KITITAS COUNTY

MEMORANDUM

TO: All Staff
FROM: Public Works Plan Review Team
DATE: November 7, 2022
SUBJECT: SX-22-00021 Sporar

<b>FEMA BASED ZONE MAP</b>		
PREPARED FOR <b>MR. TOM SPORAR</b>		
KITTITAS COUNTY,	DATE	RSN NO.
OWN BY <b>AGJ</b>	<b>12/07</b>	<b>07178</b>
DRAWN BY <b>R. BOGDON</b>	SCALE <b>1"=20'</b>	SHEET <b>1 of 1</b>

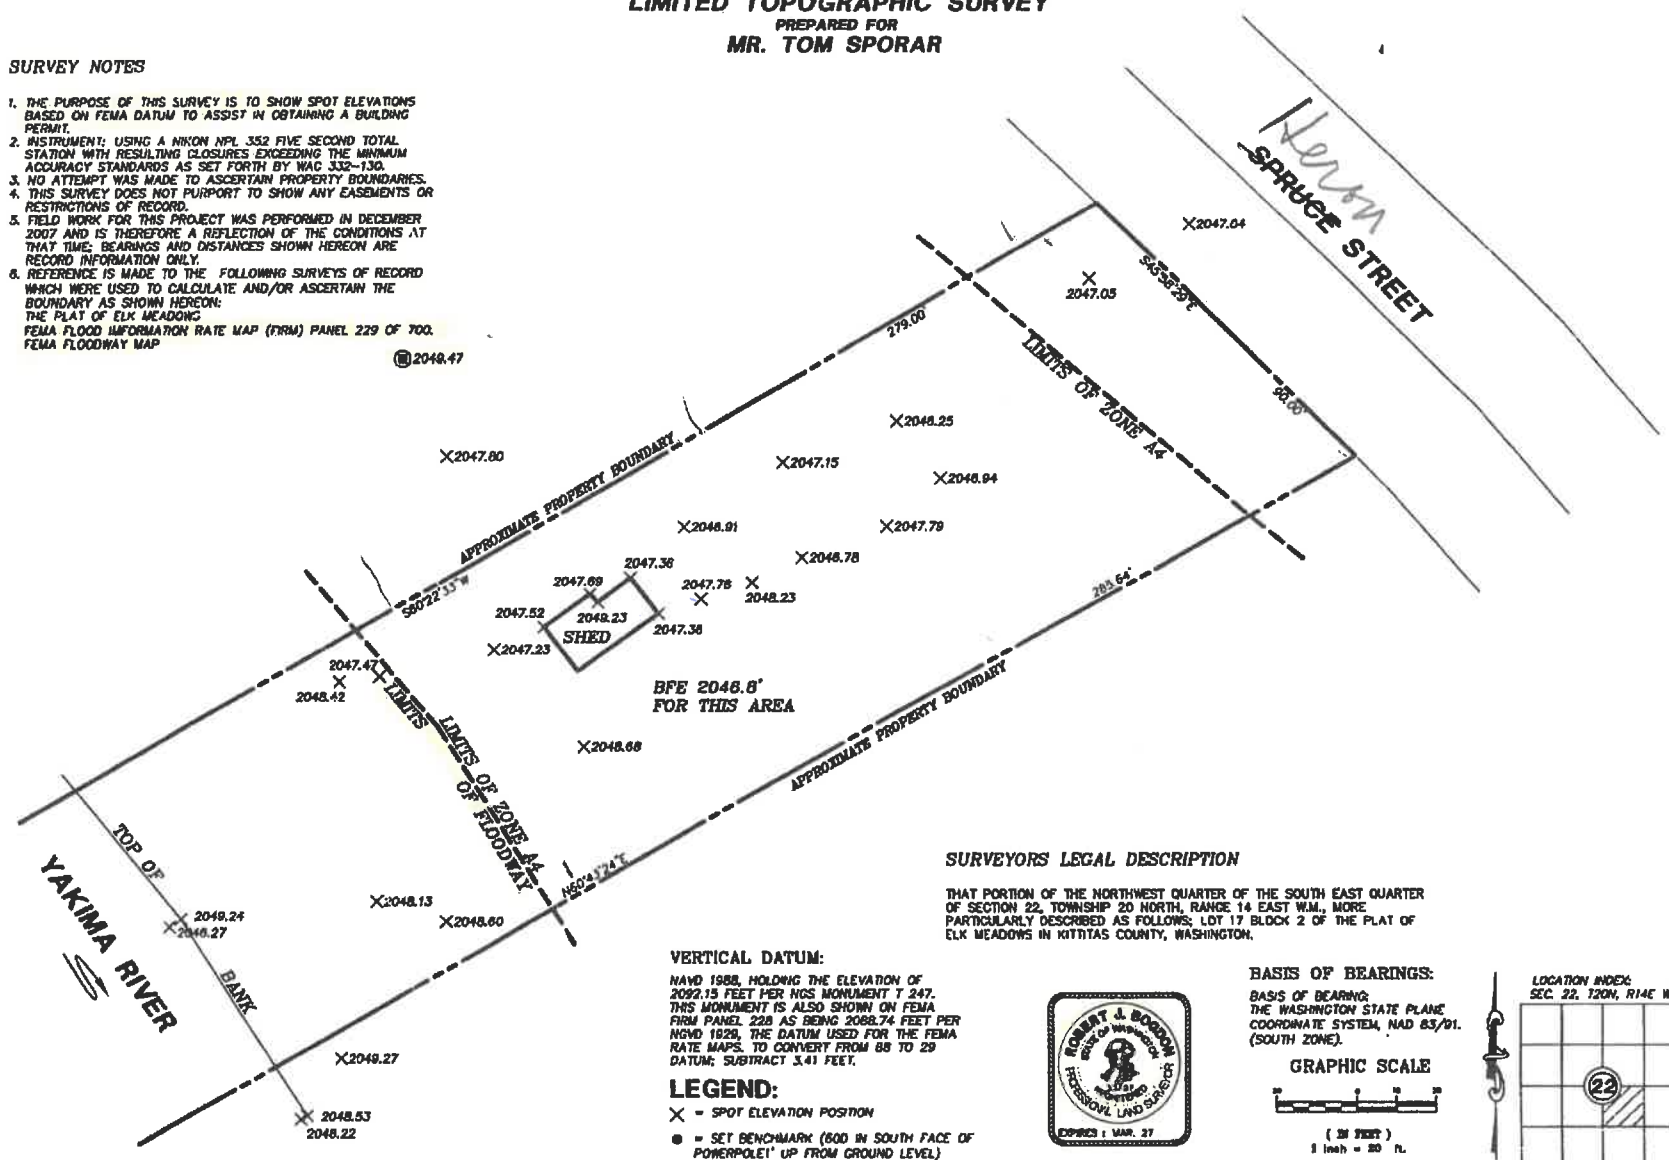
The parcel contains FEMA-designated Floodway. A review of available information (site plan and aerial photography – see attached map) indicates that the cabin encroaches in the floodway. No new or substantially improved residences are allowed within the Floodway. A surveyor will need to identify the floodway boundaries on site and the cabin and deck will need to be located outside the floodway.
